14TH November
~~15TH~~ 2012

Re: Planning Application R/175/12 - No. 46 Seafield Road, Rustington, BN16 2JQ

SCHEMATIC OF N° 46 TO BE DEMOLISHED 1/200

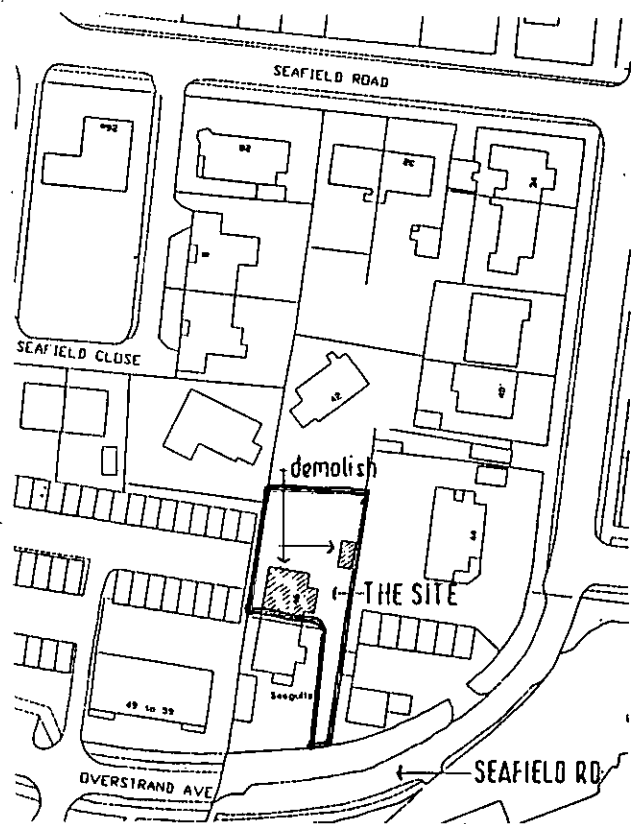
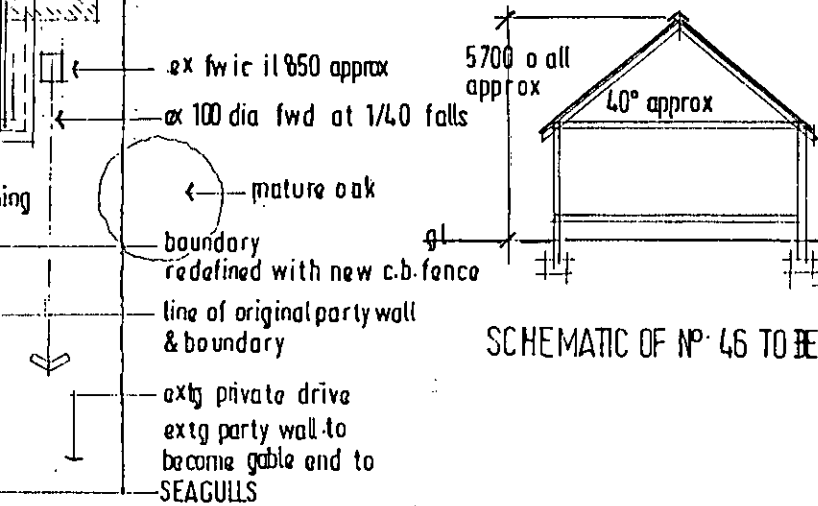
2. The drawing of the existing building cannot be correct in that it creates the impression that the existing four bedroom dwelling is being replaced with a new four bedroom dwelling. The drawing of the existing dwelling has no kitchen and so in fact it is at most a three bedroom dwelling. It is interesting to note that the GIA (Gross Internal Area) of the proposed dwelling is in excess of 2,050ft² compared to the existing dwelling which has a GIA of approximately 650ft². Interestingly the Ground Floor GIA comparison is 1190ft² for the proposed dwelling compared with 650ft² for the existing dwelling, a 68% increase in footprint. The overall increase in GIA for both floors of the proposed dwellings compared with the existing dwelling represents a 215% increase in area. Quite simply this demonstrates that the proposal is inappropriate and, as mentioned above, is an overdevelopment of the small site.

SOUTH [front] 1/100

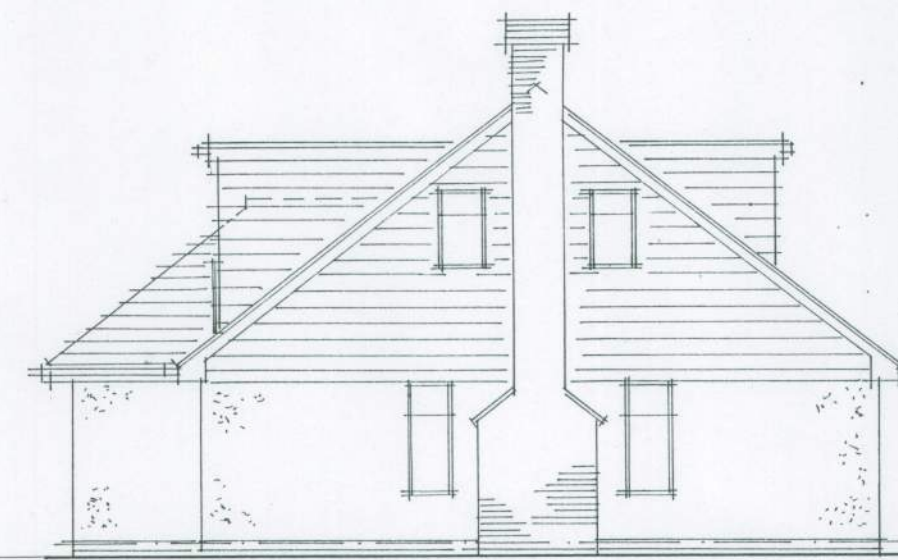
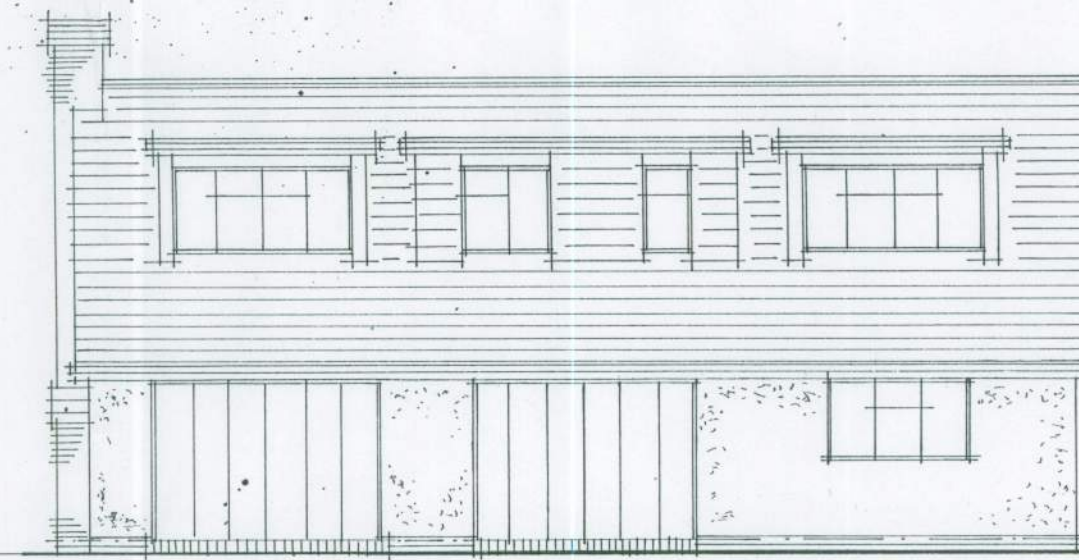
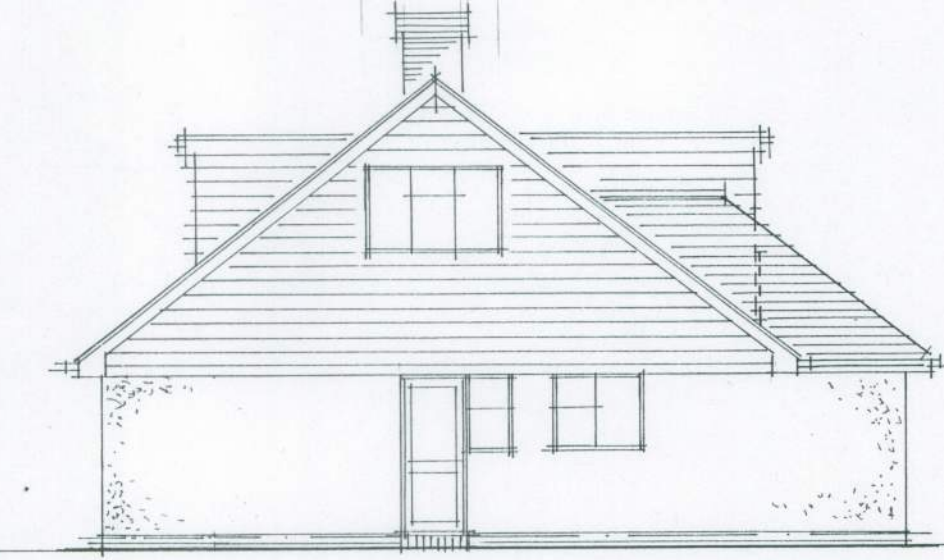
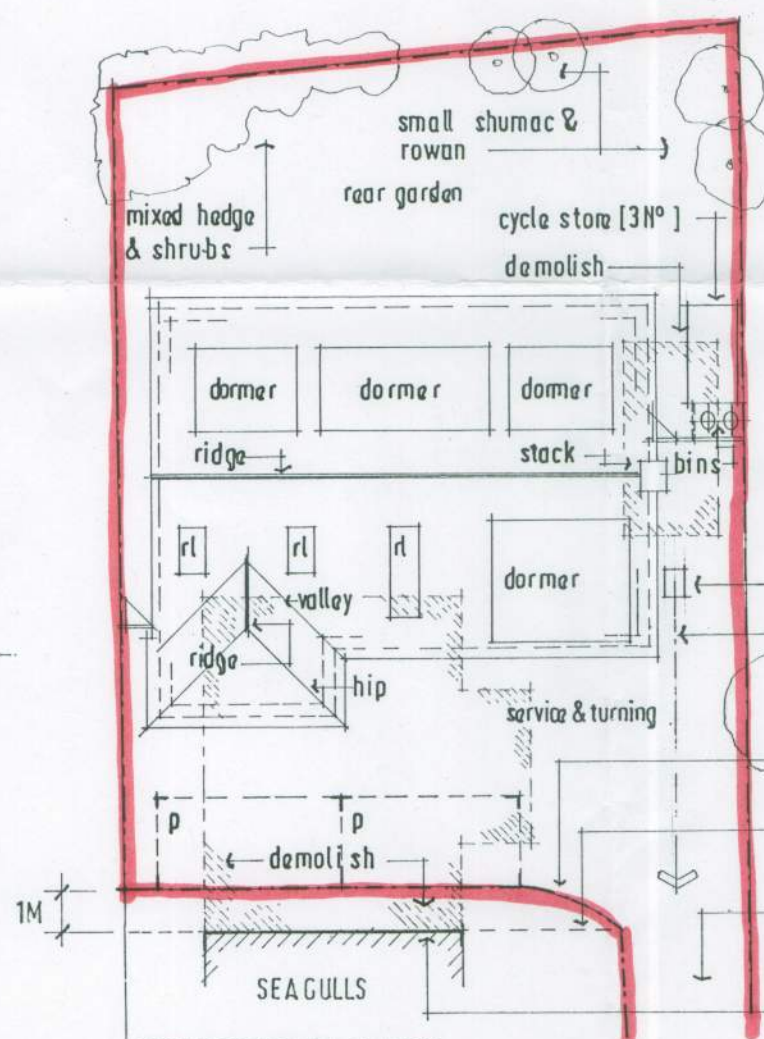
3. Apart from the positioning of the proposed dwelling on the site we are concerned that the ridge height of the proposed dwelling is 6.00M when compared with the existing dwelling height of 5.70M.

SITE/ROOF PLAN 1/200

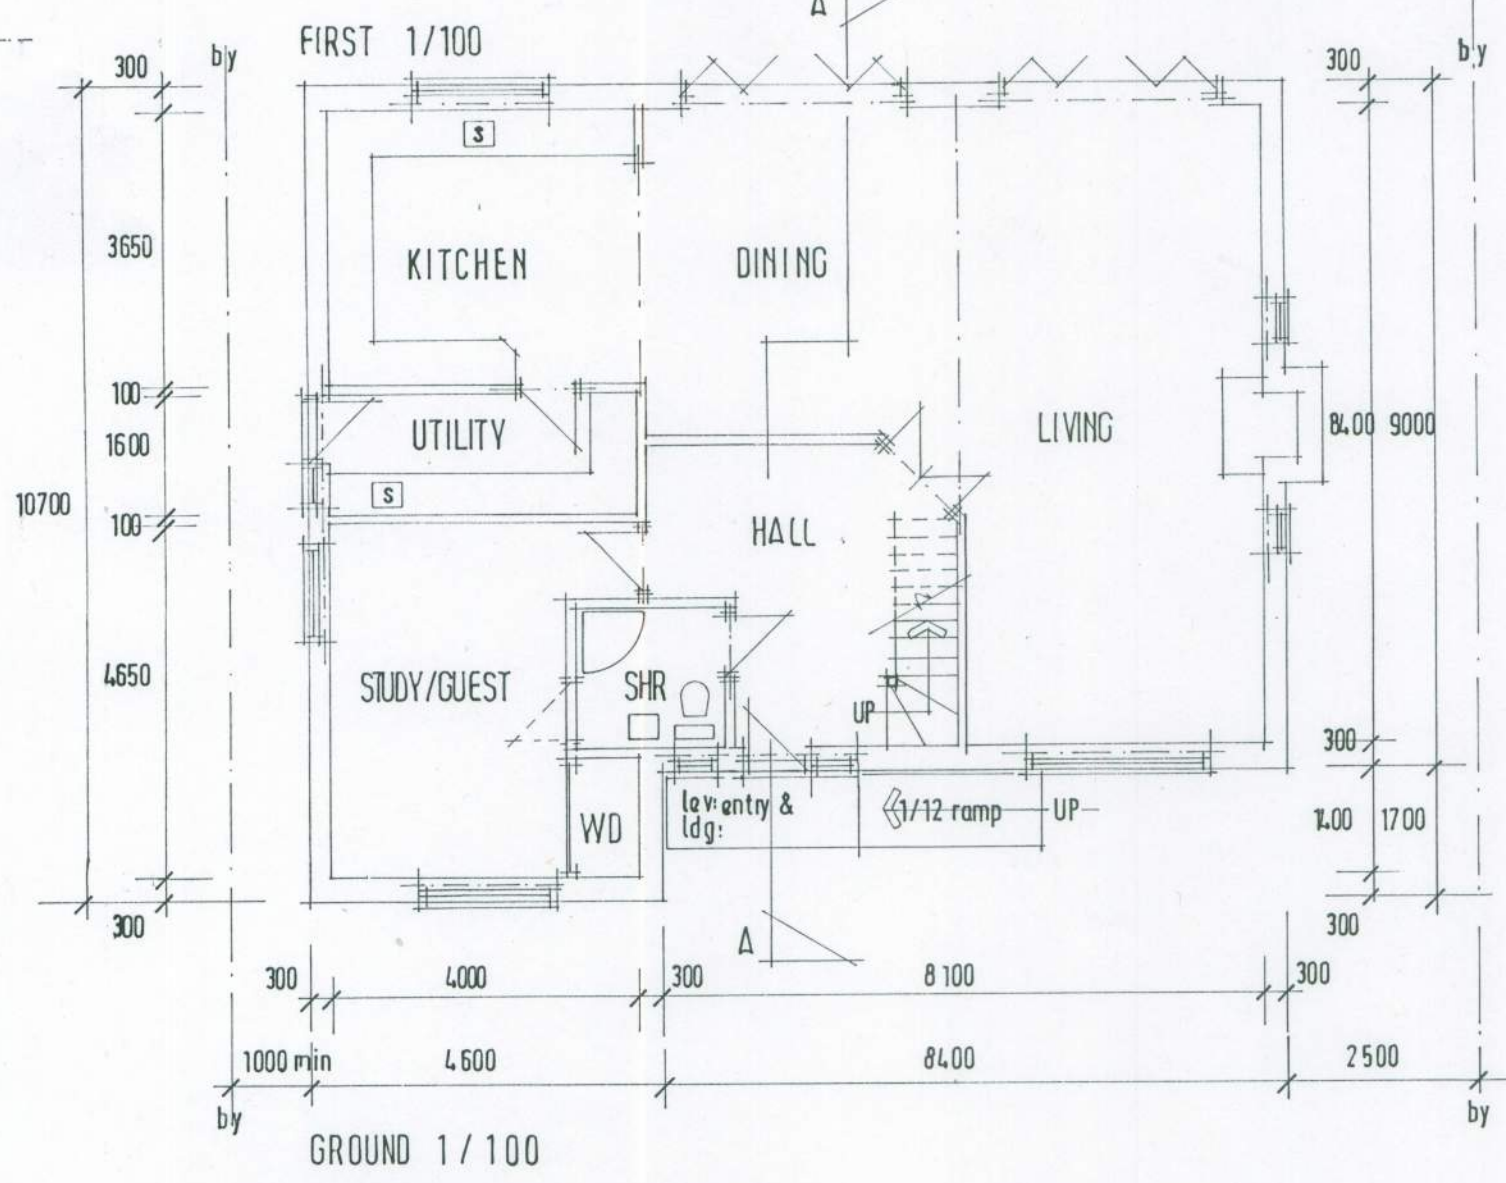
1. The development in our opinion is an overdevelopment of the current site in relation to the surrounding buildings. The existing building is a relatively semi-detached single storey retirement/ holiday bungalow whereas the proposed development is a large detached two storey family home which is built tight to the West and East boundaries and leaves little space to the front or rear (South and North) of the site. It is evident that the mass of the development is inappropriate when compared with the surrounding area.
